Planning Application Ref: EG/57/16/PL (2) **Current comments in blue typeface**

Location: Land adjacent to the Croft Practice, Barnham Road, Eastergate

Description of works: Construct a medical centre with access and parking arrangements.
Applicants have submitted a revised AMS report & Tree Protection Plan –DLA April 2017 & Plan TP 2160/1704/TPP 22Apr17

TITLE			
Tree Protection Plan Eastergate			
SIZE	CAGE CODE	DWG NO	REV
A3		TP 2160/1704/TPP	
SCALE	1:200	22 Apr 2017	SHEET

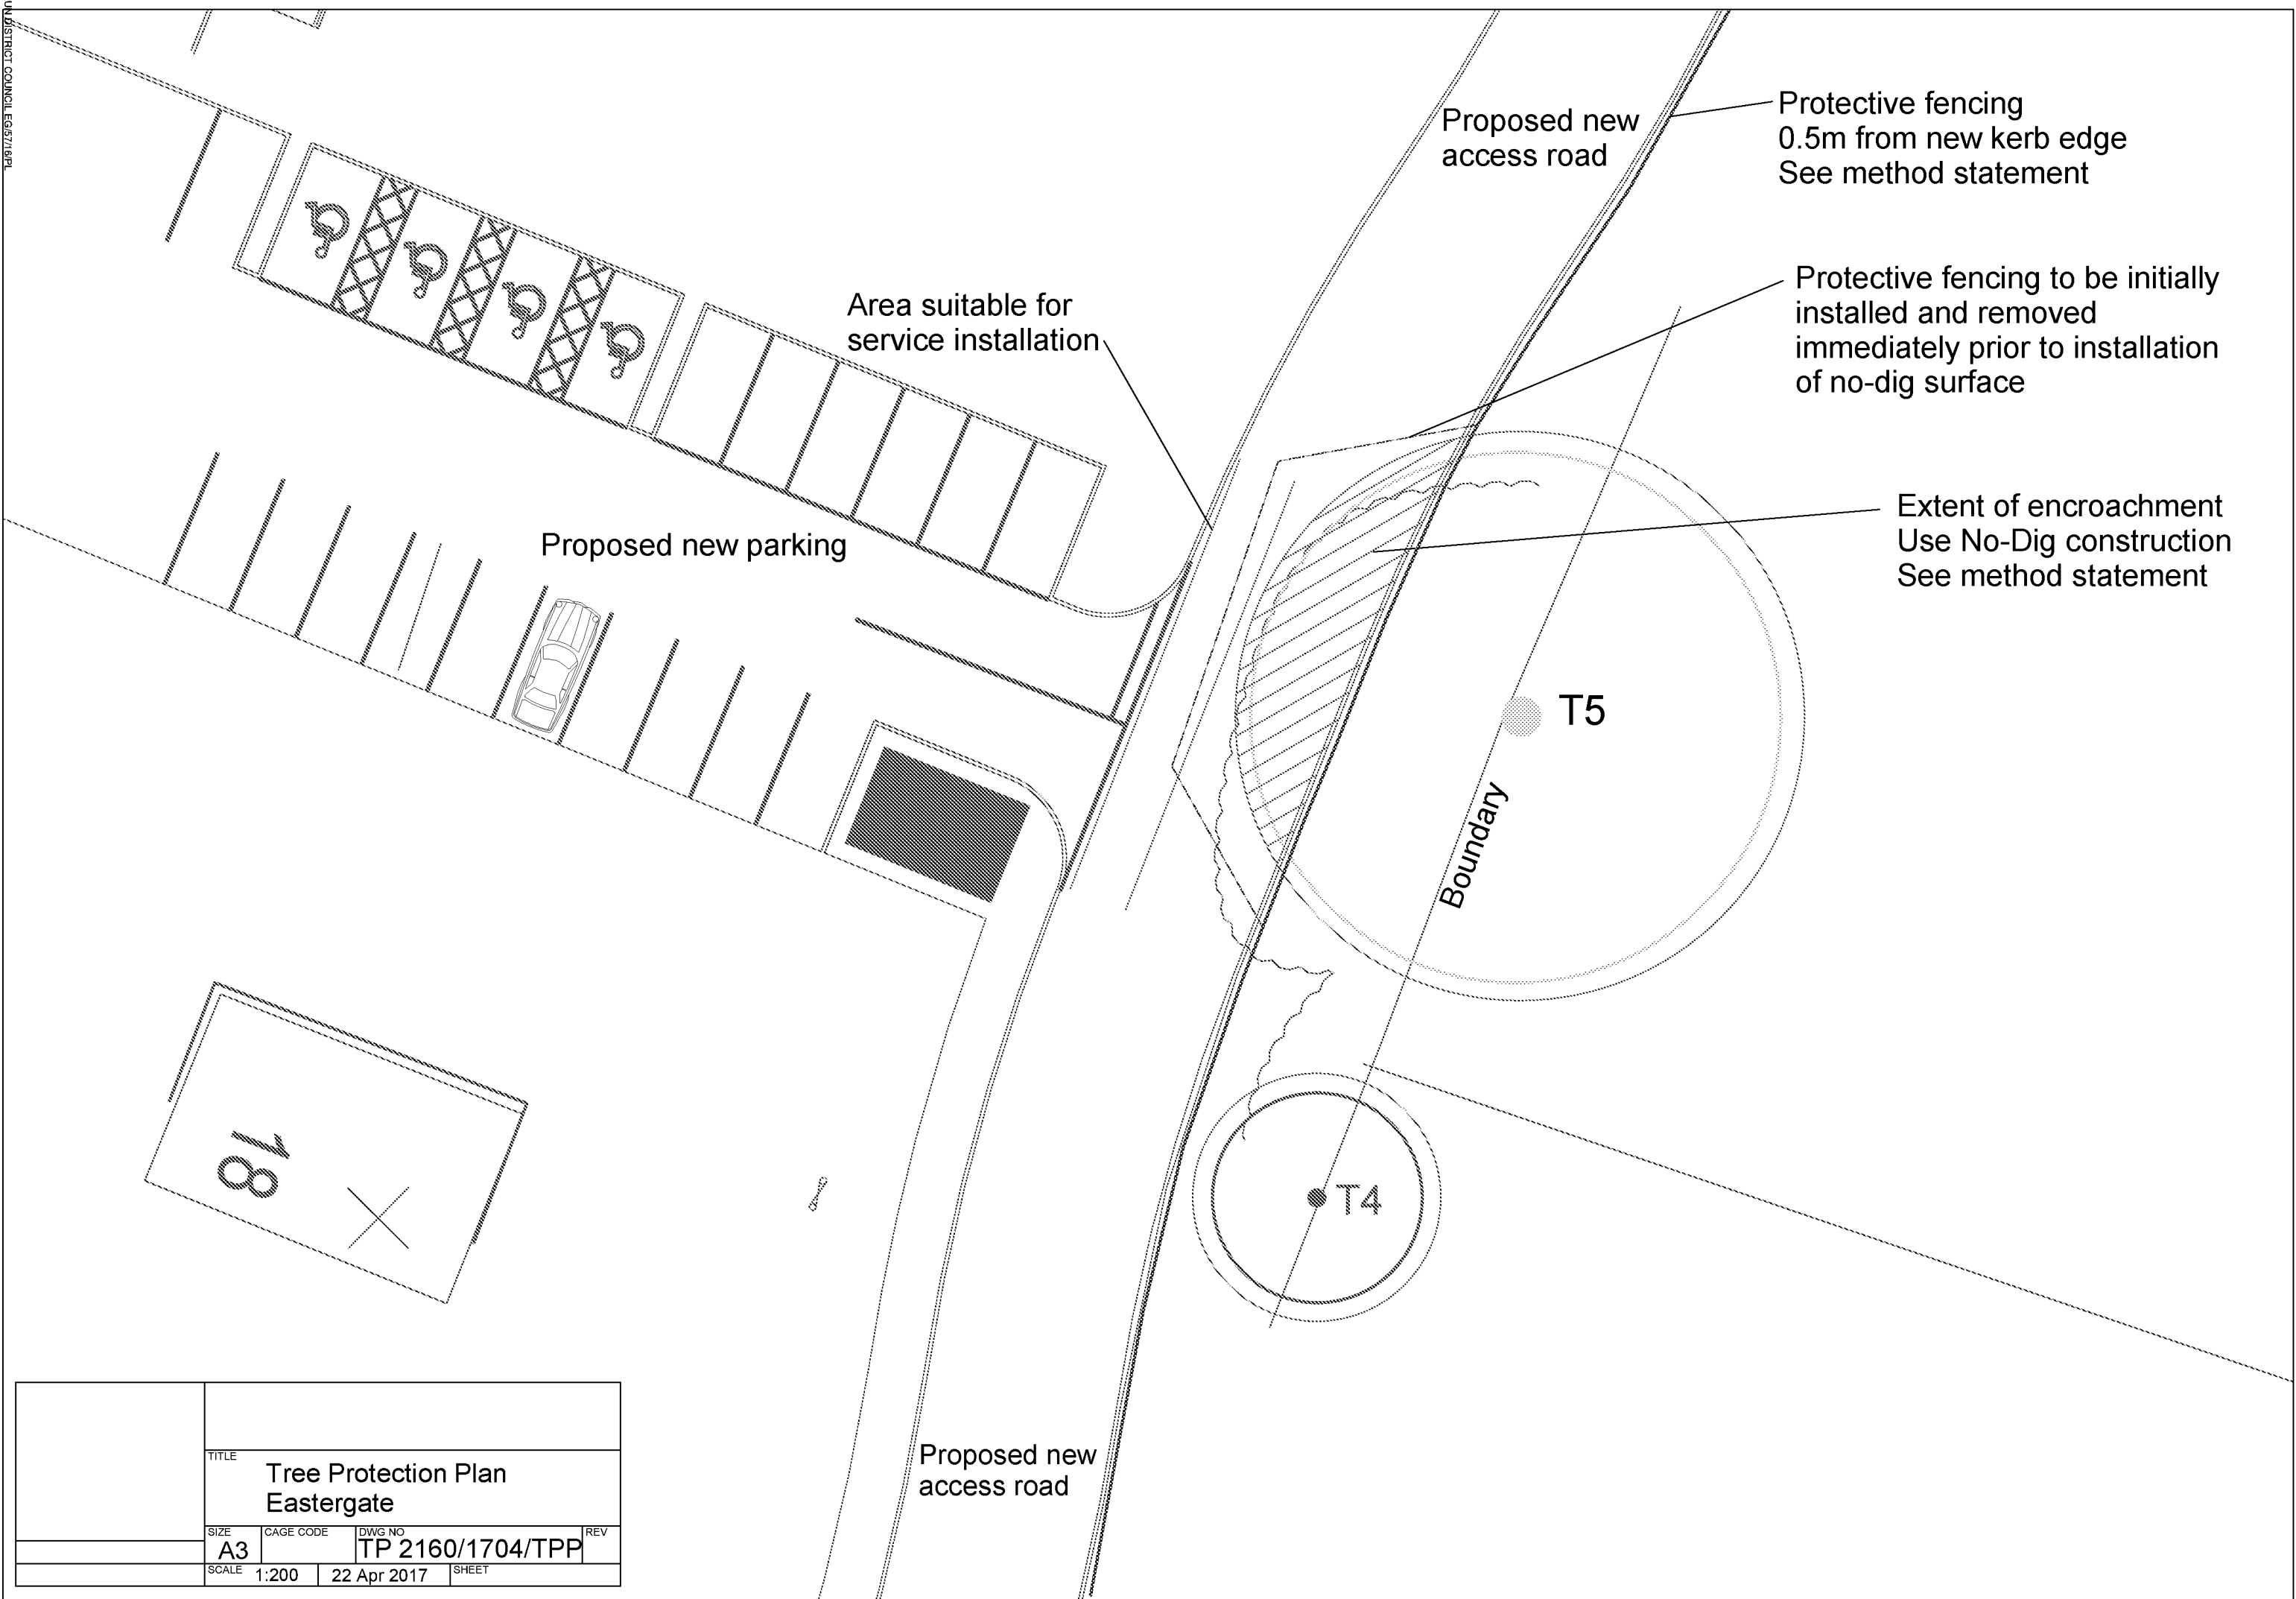
- I am not happy with the relationship of this tree to the proposed development and in particular the access road which cuts right through the RPA. I see no need for this when there is adequate space to keep outside of the RPA altogether.

- **I am disappointed to see that instead of looking for a solution by revising the layout to accommodate the tree as per BS5837 recommendations they have sought to apply mitigation measures with a 'No Dig' solution – this in my opinion is 'making it fit' the original layout rather than adjusting same and designing out any conflict with the tree.**

- The Tree Survey report is brief but acceptable and the Constraints Plan likewise but sadly it has not informed the design and the proposed access road cuts right through the RPA exceeding the maximum of 20% of hard surfacing within an RPA advised under BS5837 and having the potential to have a serious and damaging effect on this fine specimen Oak tree.

- **I am not satisfied with the alternative proposals and still seek a revised layout that accommodates the full tree RPA as I do not see why the whole development cannot be moved further over to the west away from the tree and any loss of parking in the southern sector added to the northern sector where there is scope to accommodate it.**

- I wish to register an **OBJECTION** to this scheme because of the high potential for it to have a serious and damaging effect on the fine off-site specimen Oak tree listed as T5 in the survey data. Furthermore there is no Arb Method Statement & Tree Protection Plan submitted to explain how this impact can preferably be avoided or at the very least mitigated.
- In view of the threat to this fine tree I recommend that a TPO is made to protect it and include a TEMPO assessment and location plan with this report.
- **OBJECTION sustained.**
